ATC SITE NAME: BLACK FOREST
 ATC SITE NUMBER: 302460
 VERIZON SITE NAME: BLACK FOREST
 VERIZON SITE NUMBER: 5000265154
 VERIZON FUZE PID: 16583882
 SITE ADDRESS: 4584 HODGEN ROAD
 COLORADO SPRINGS, CO 80908

VERIZON AMENDMENT DRAWINGS

SHEET NUMBER: C-101	REVISION: 0
-------------------------------	-----------------------

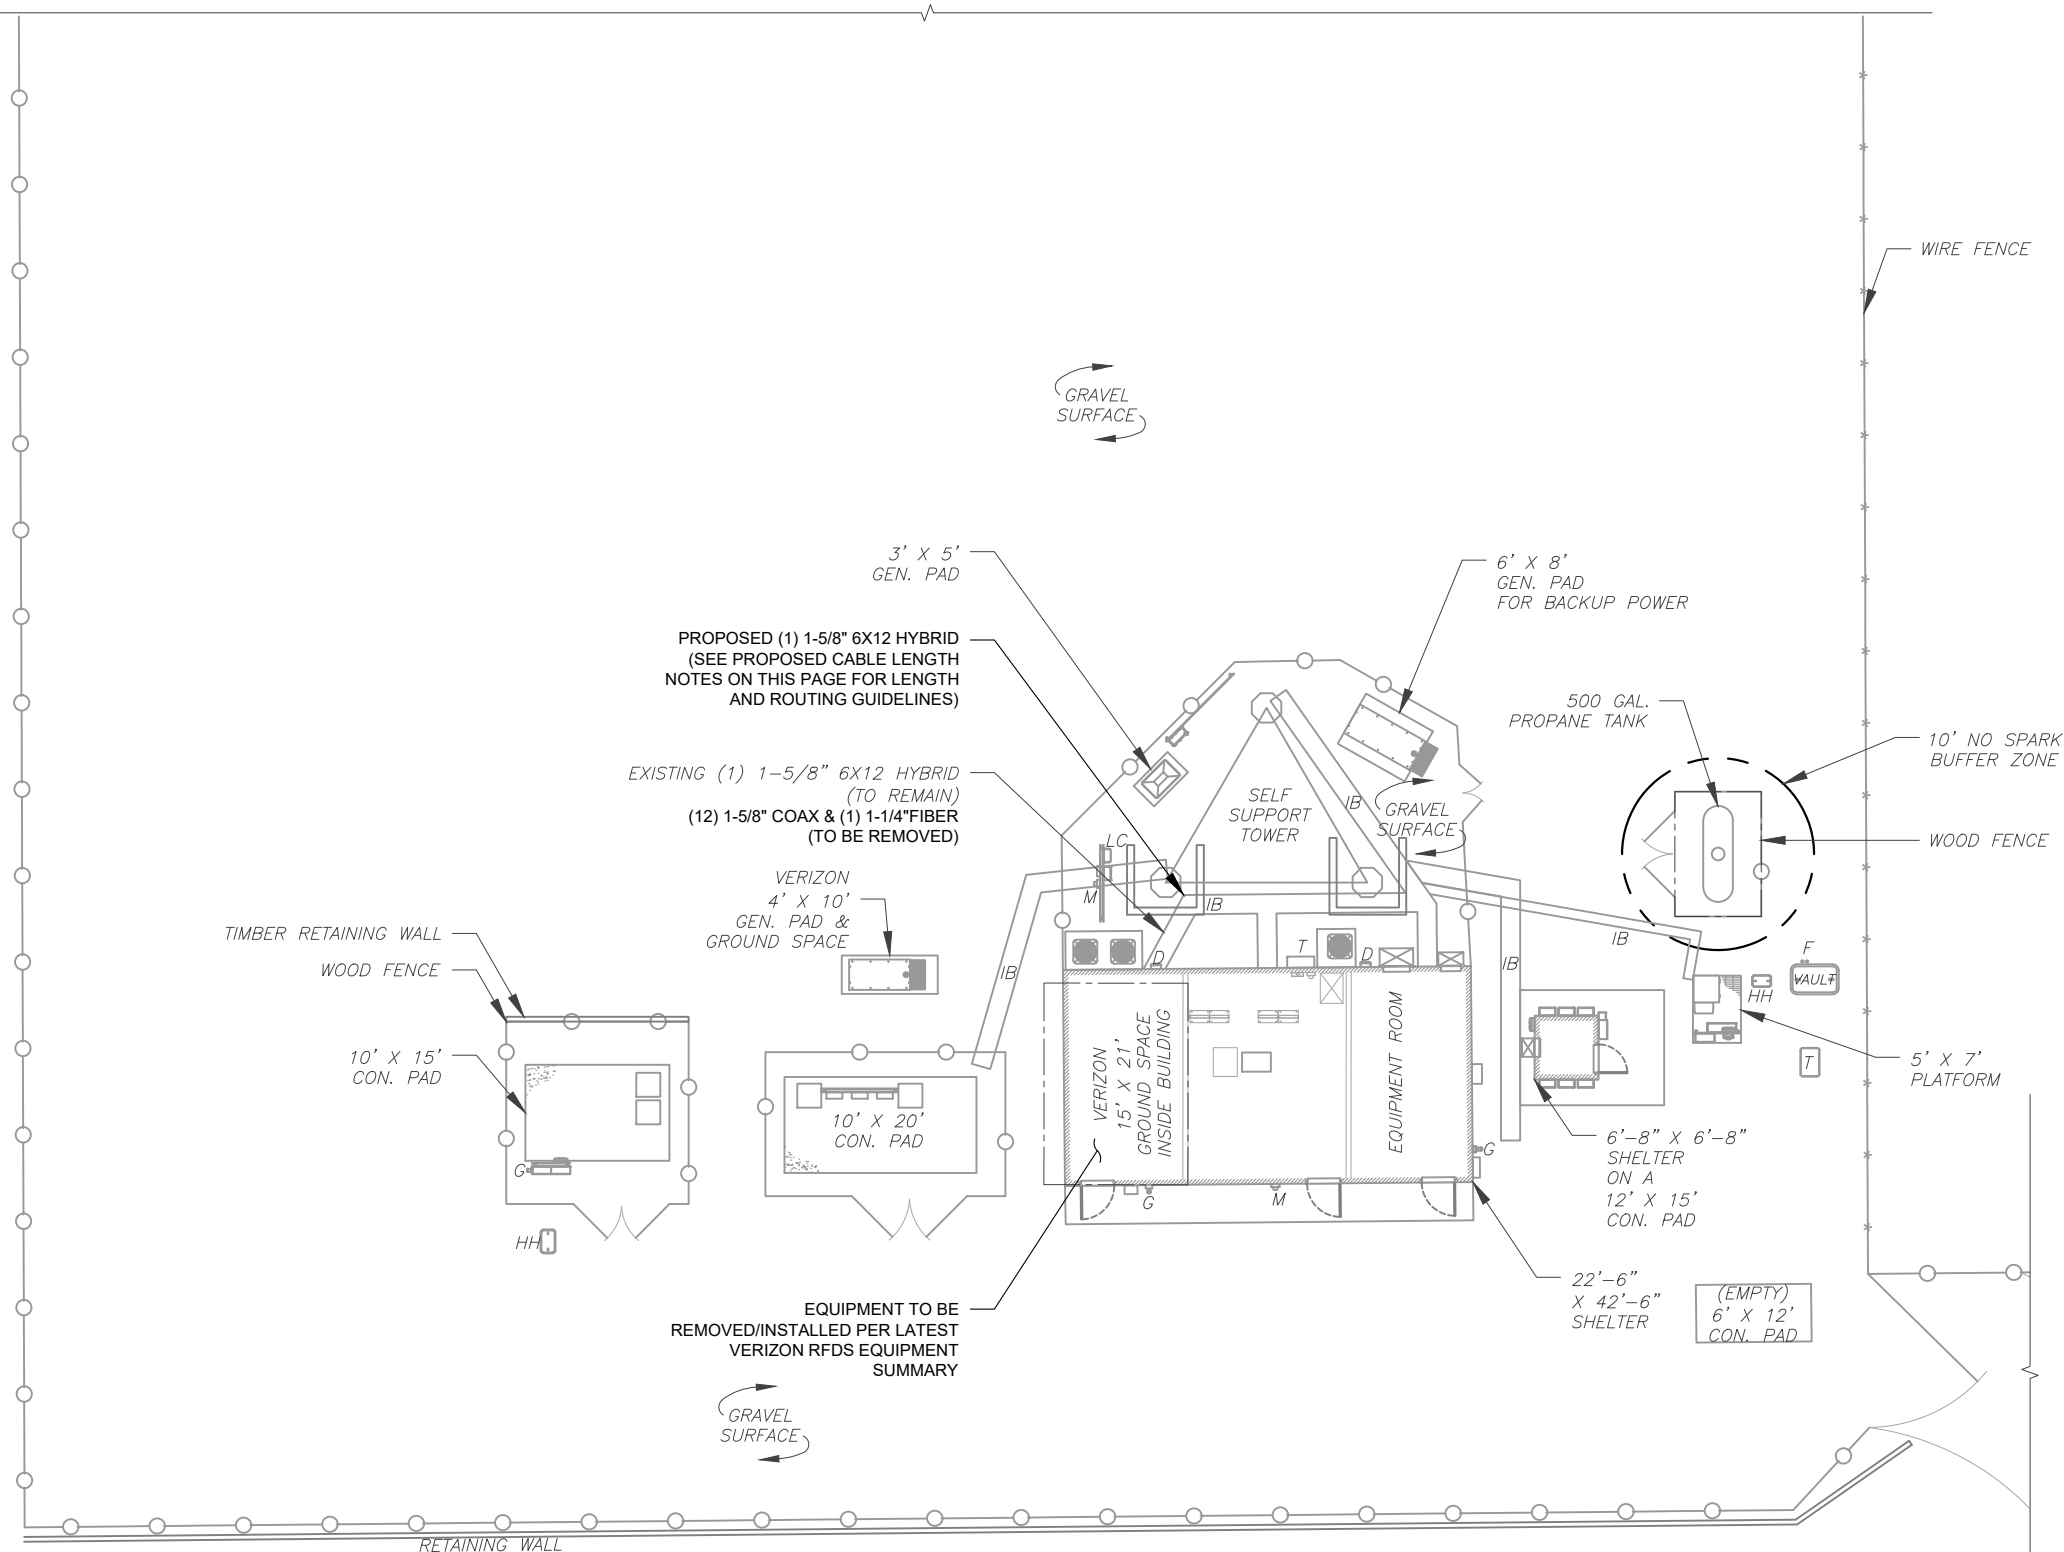
Please add:

- [] the location of all property lines for the parcel.
- [] the dimensions of all property lines.
- [] the adjacent right of way

(Please refer to the previously approved "overall site plan" of file number COM2218 as an example.)

- [] add distance measurements between all existing and proposed structures to the property lines.

Is this a concrete pad or will this be a new generator? This does not appear to be identified on past approvals but is not identified as new?

Does this need to be added to the proposal? This does not appear to be identified on past approvals.

1 TOWER ELEVATION
SCALE: N.T.S.

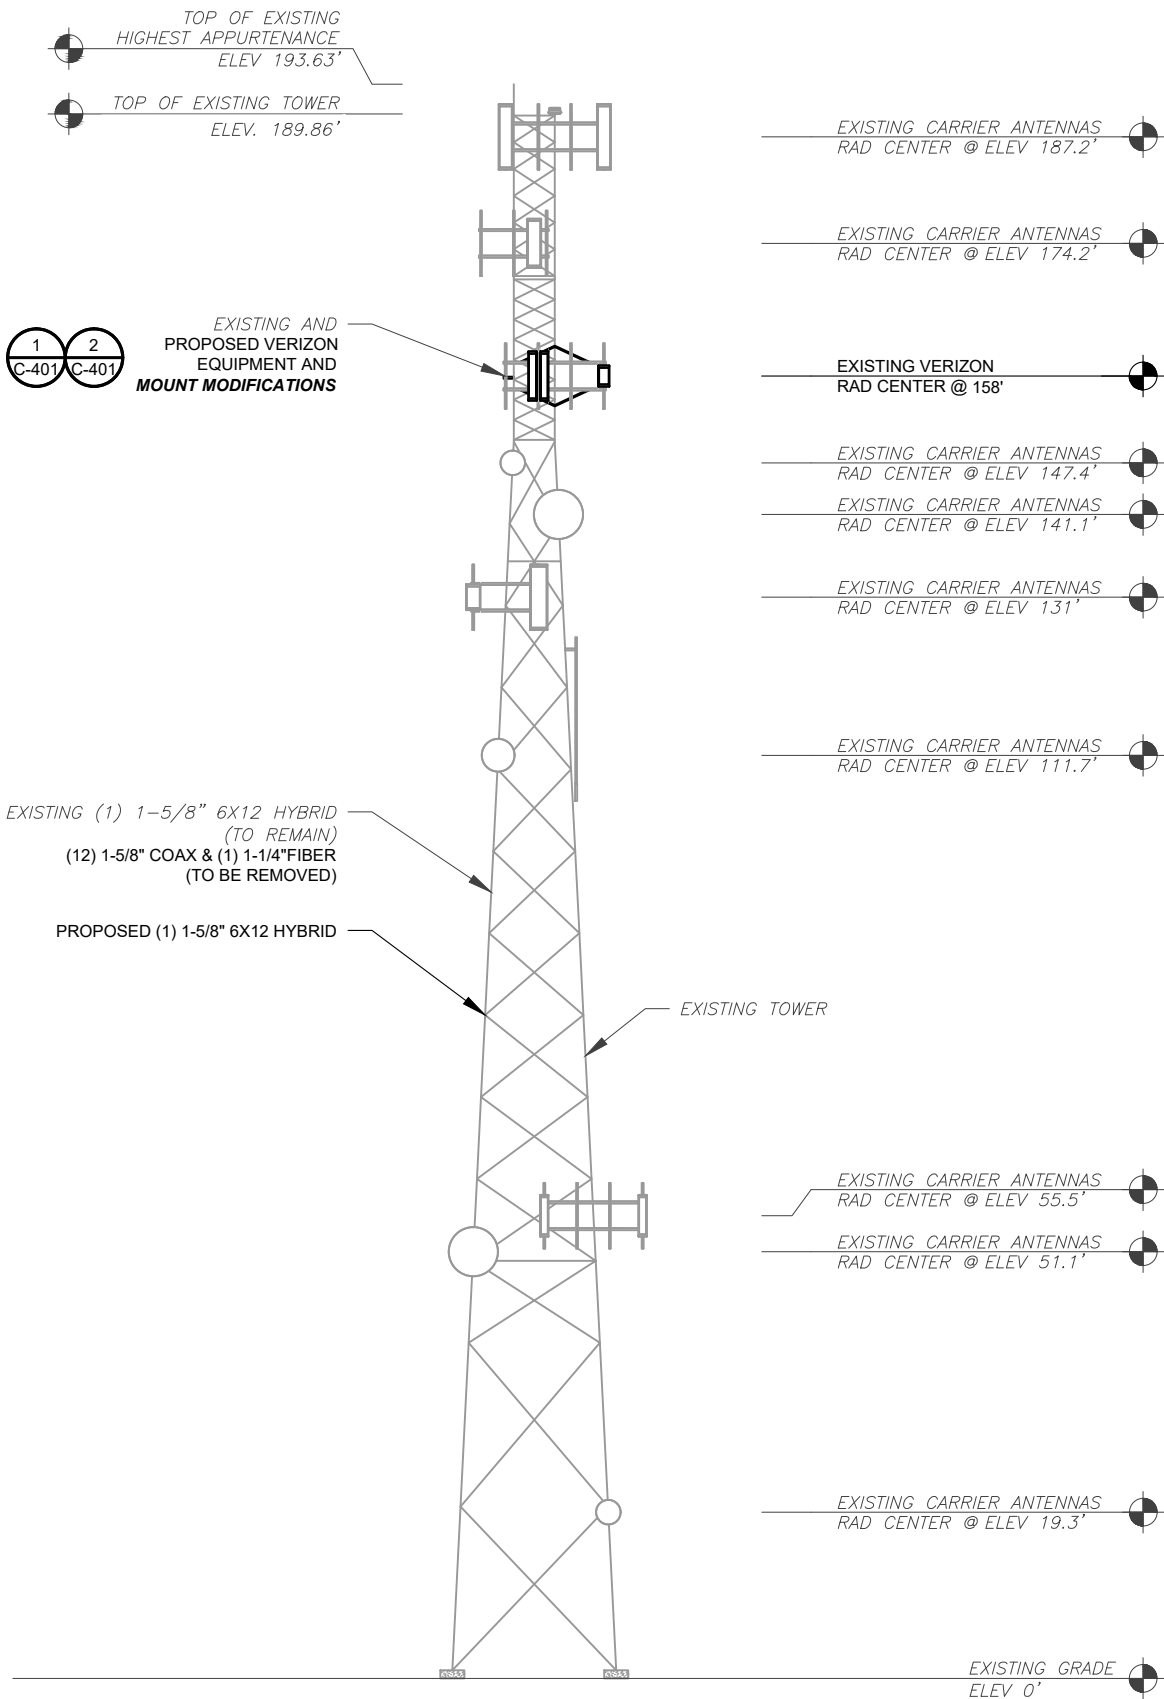
Variance of Use approval (VA211) and all previous PPR- / COM- / TWR- approvals have identified a 170' height limit to this tower. Most recent file numbers include PPR2127 and COM2218. I do not see approval for an increase to this limit with our department.

If you are proposing to exceed the approved height limit, a new Variance of Use may be required per LDC Section 5.2.19(B)(6)(e)(i) -

"A modification constitutes a Substantial Change if: (i) It increases the height of the tower by more than 10% or by the height of one additional antenna array with separation from the nearest existing antenna not to exceed twenty feet, whichever is greater; for other eligible support structures, it increases the height of the structure by more than 10% or more than ten feet, whichever is greater. Changes in height should be measured from the original support structure in cases where deployments are or will be separated horizontally, such as on buildings' rooftops; in other circumstances, changes in height should be measured from the dimensions of the tower or base station, inclusive of originally approved appurtenances and any modifications that were approved prior to the passage of the Spectrum Act;"
